MEMORANDUM

TO: All Staff
FROM: Public Works Plan Review Team
DATE: April 10, 2026
SUBJECT: RU-26-00001 Pazaruski

LOT 9 HYAK ESTATES 2 GRADING DESIGN
RYAN PAZARUSKI
SITE PLAN

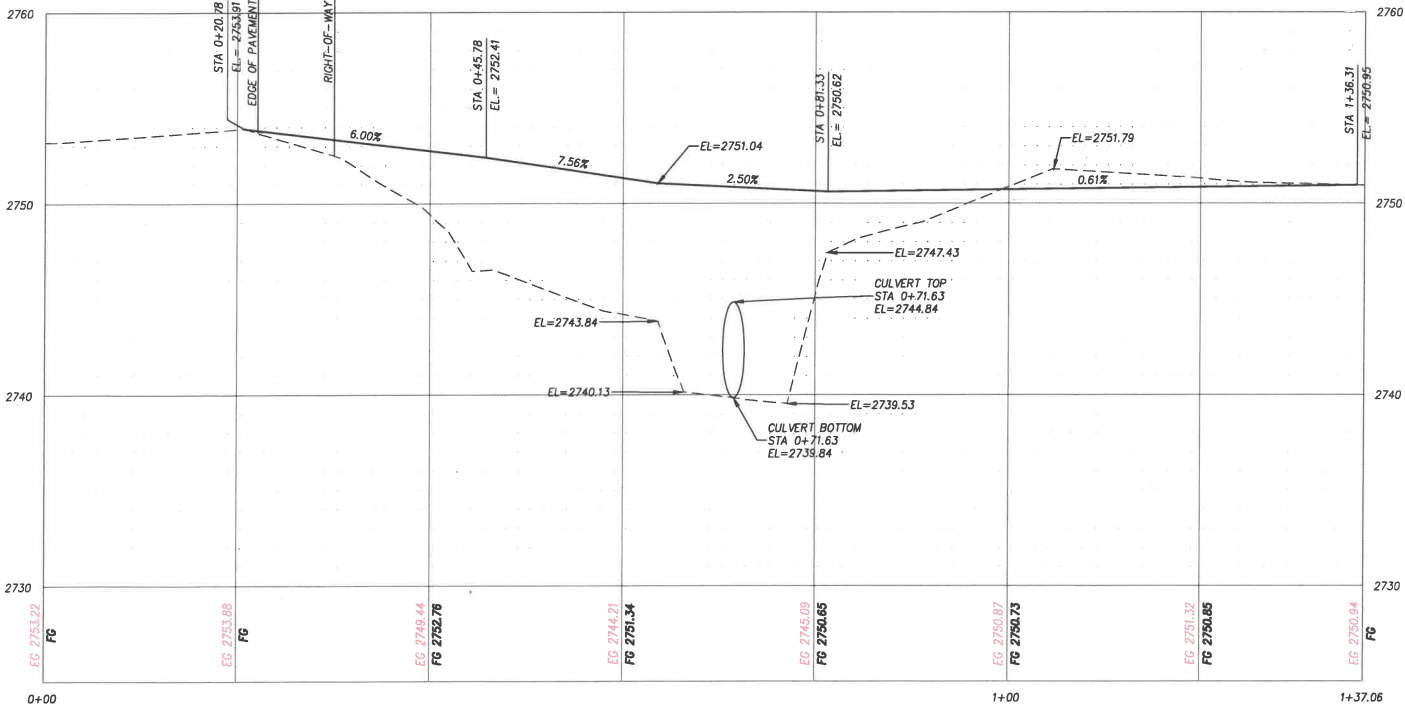
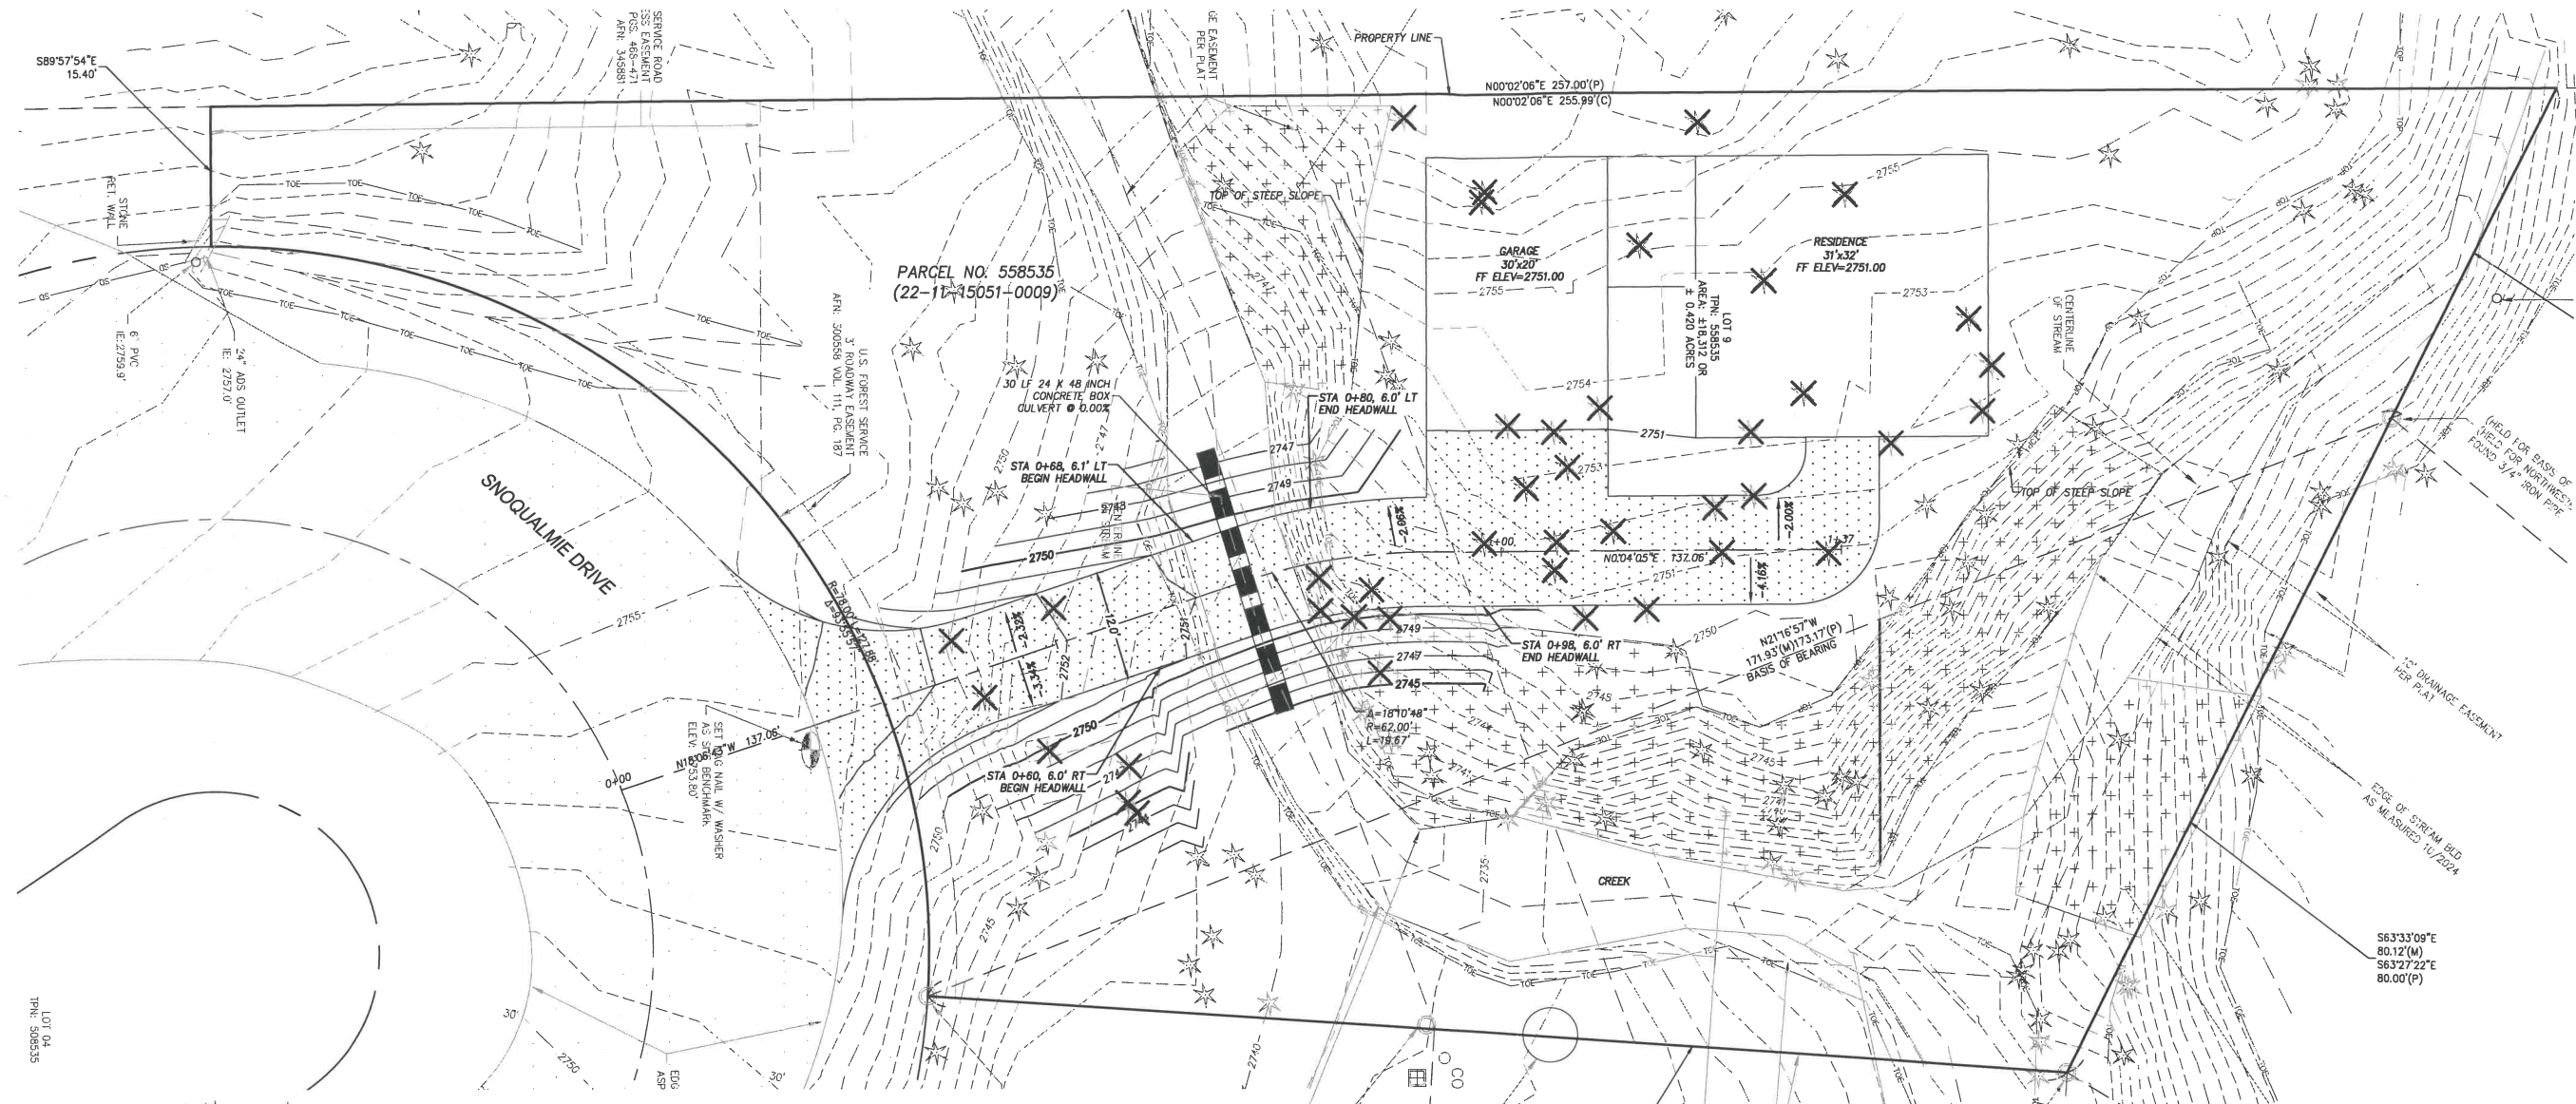
SURVEY	Site plan does not meet the new requirements of WAC 332-130-145. (JT)
TRANSPORTATION CONCURRENCY	No comment.
